# BusConnects Dublin Core Bus Corridor Projects

Corridor 2 – Swords to City Centre

Emerging Preferred Route - Public Consultation Report 2018/2019

REFER TO MAP 43 FOR ALTERNATIVE TRAFFIC ROUTES - SANTRY

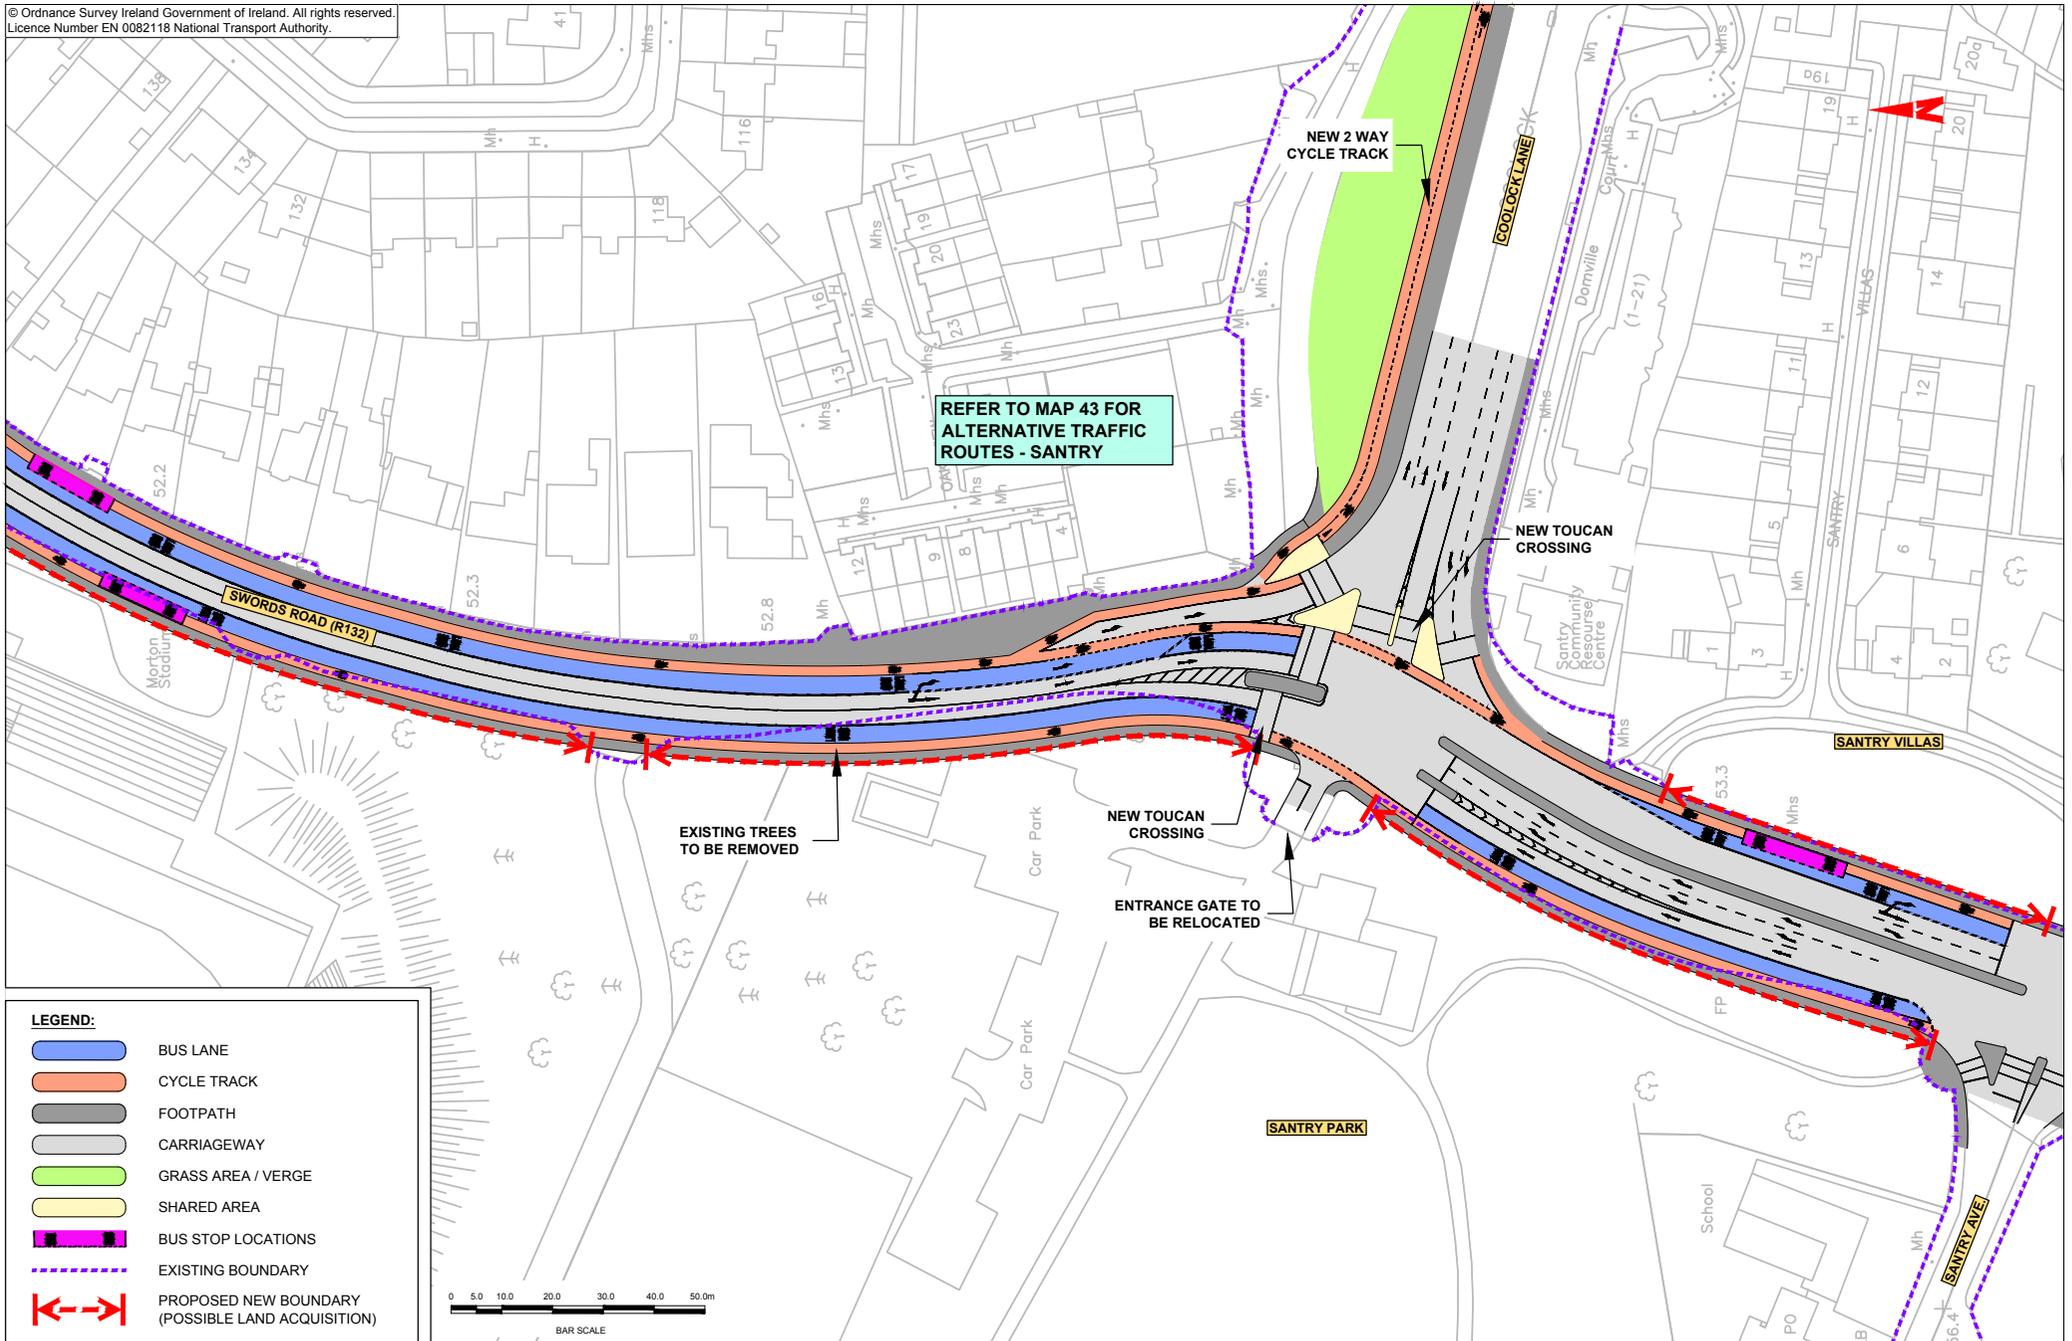
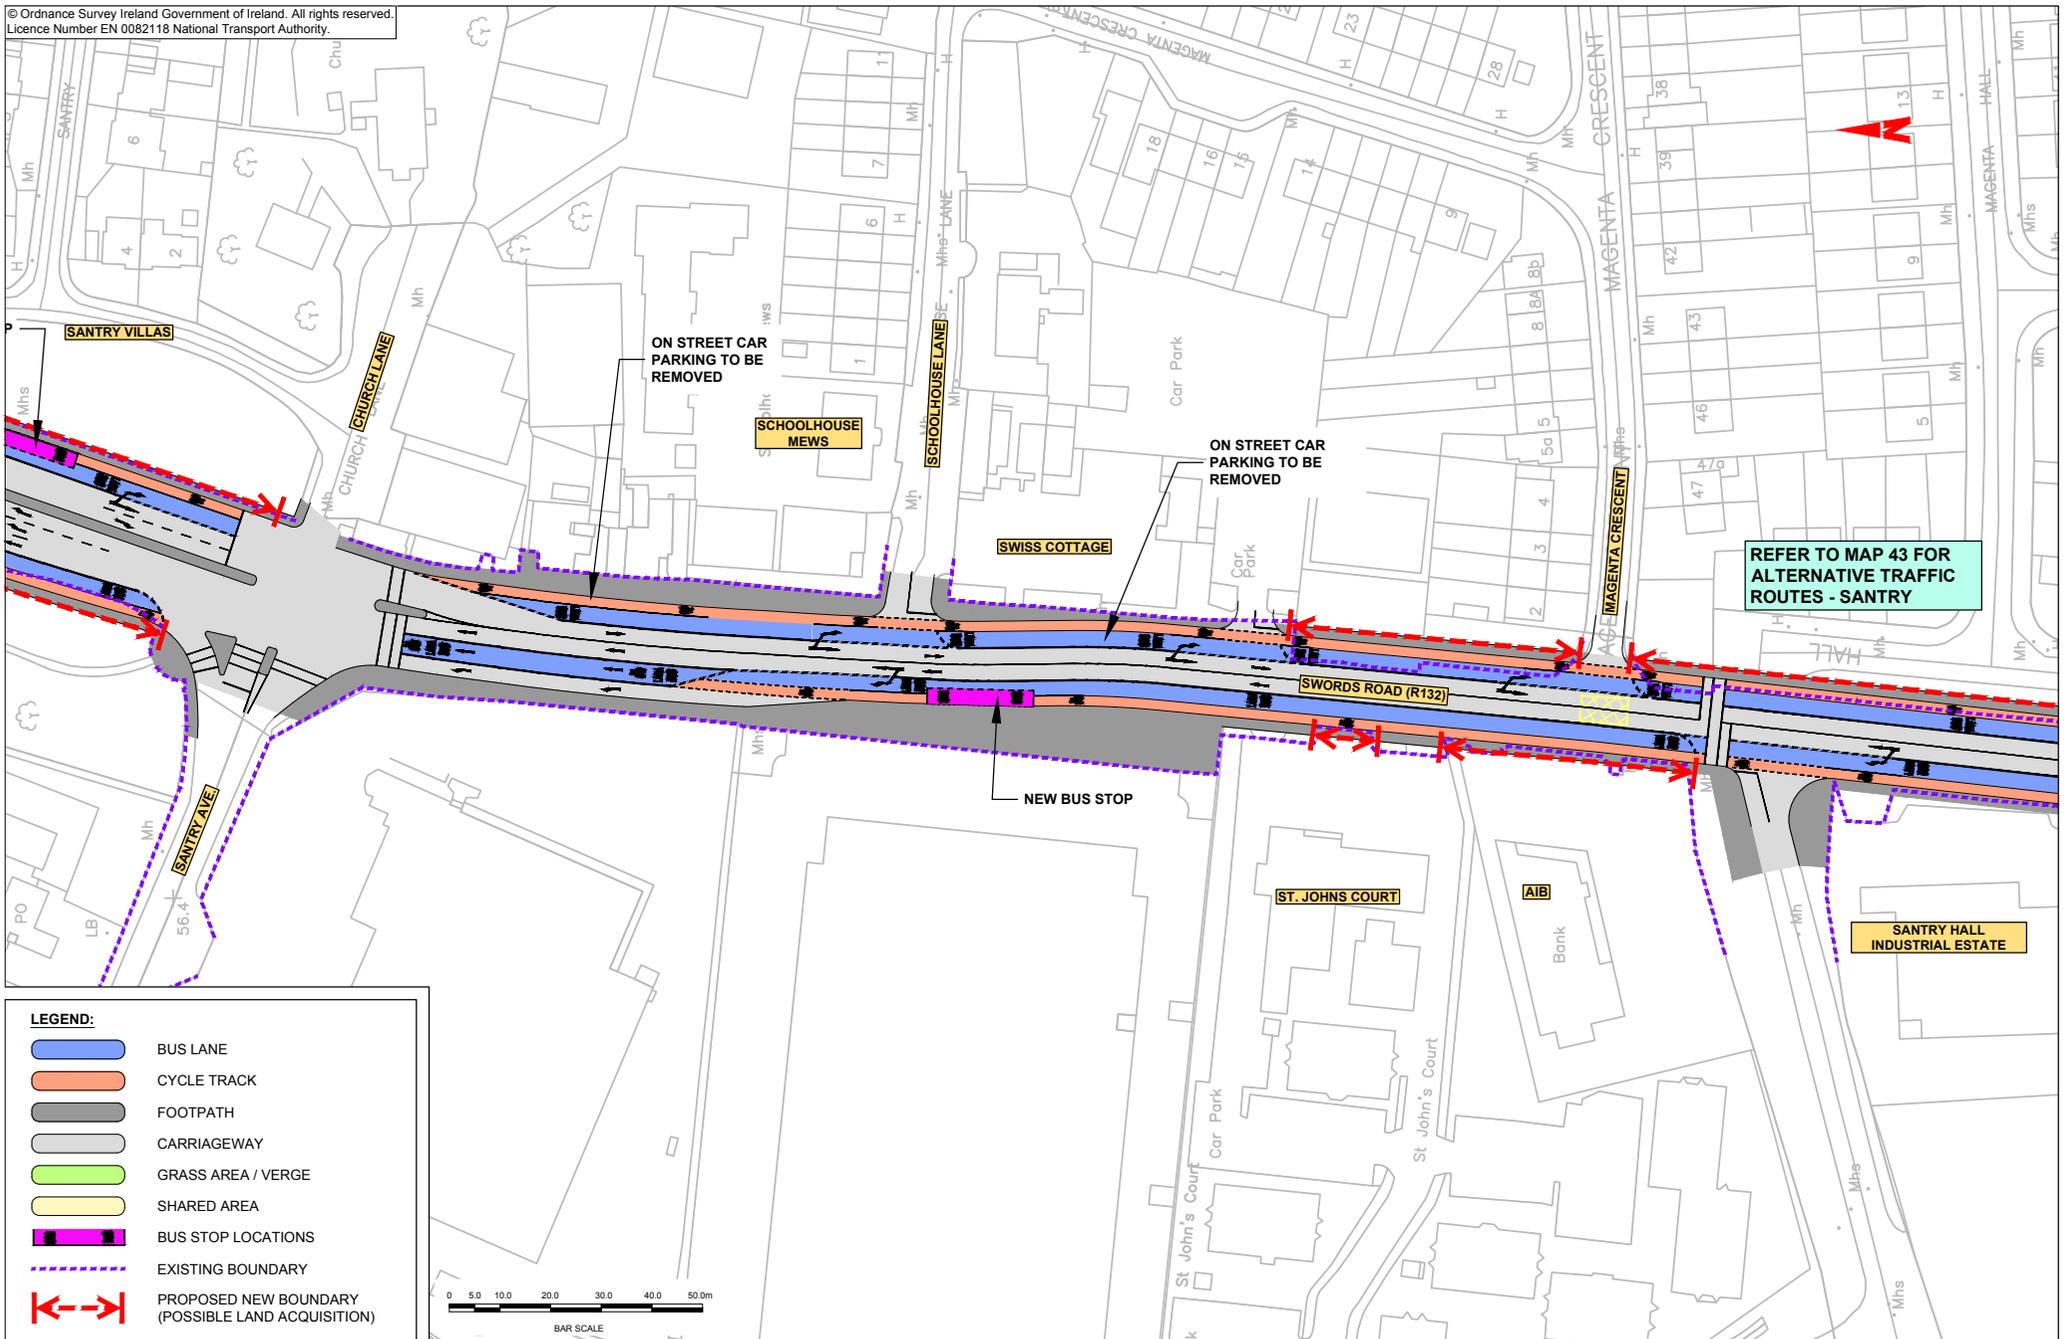
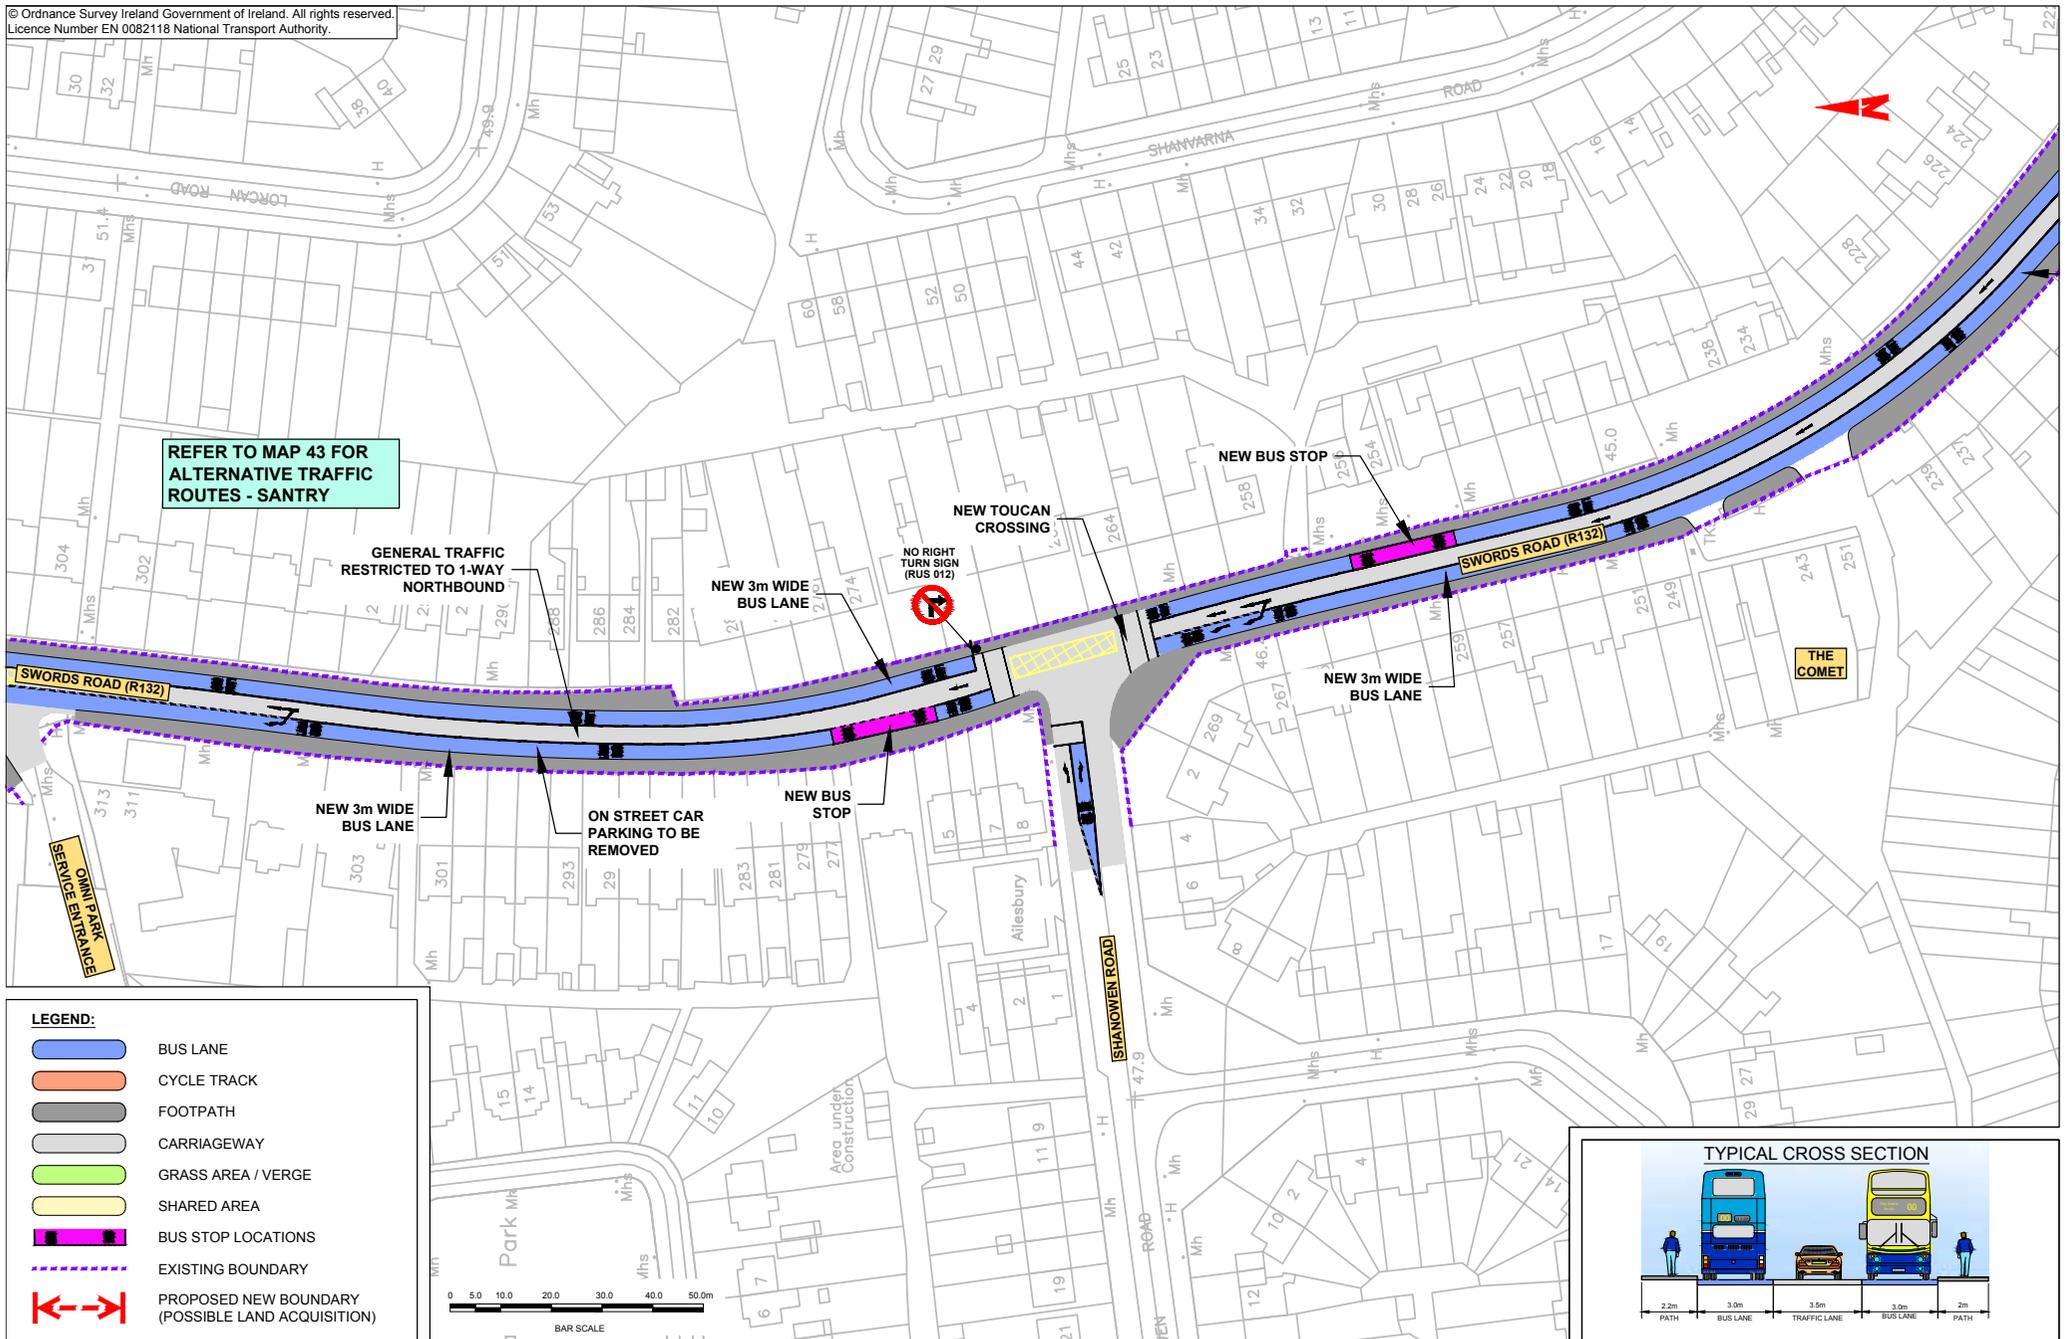
The majority of submissions received from the residents expressed concern with the proposals along the Swords Road between Lorcan Road (opposite the Omni Park Shopping Centre entrance) and the junction with Shantalla Road. At the commencement of the public consultation a one-way traffic system was proposed between Omni Park Shopping Centre and Shanrath Road in Santry Village catering only for northbound traffic, with bus lanes in both directions, and a new southbound off ramp at the Shantalla Road - N1/ M50 Bridge (cyclists were to be taken along a separate offline adjacent route on the west side to N1/M50).

The residents contended that the one-way proposal would affect the existing access/ egress arrangements for residents along the Lorcan and Shanrath Roads, cause rat running along quiet residential areas, lead to removal of on street parking, and impact on commercial deliveries and local business. The expectation was that this proposal would increase the speed of buses along this section of corridor. However, a handful of respondents were in favour of the one-way traffic system and viewed it as an improved utilisation of existing road space for an improved public transport service.

An alternative proposal was developed during the Public Consultation, to cater for two-way traffic operation alongside bus lanes in both the directions. This proposal was supported in principle by those opposed to the one-way traffic system, while being less favoured by those concerned about the wider road cross section along this section of the corridor and the impacts on land acquisition, perceived increase in noise and air pollution, and the potential loss of the 'local village environment'.
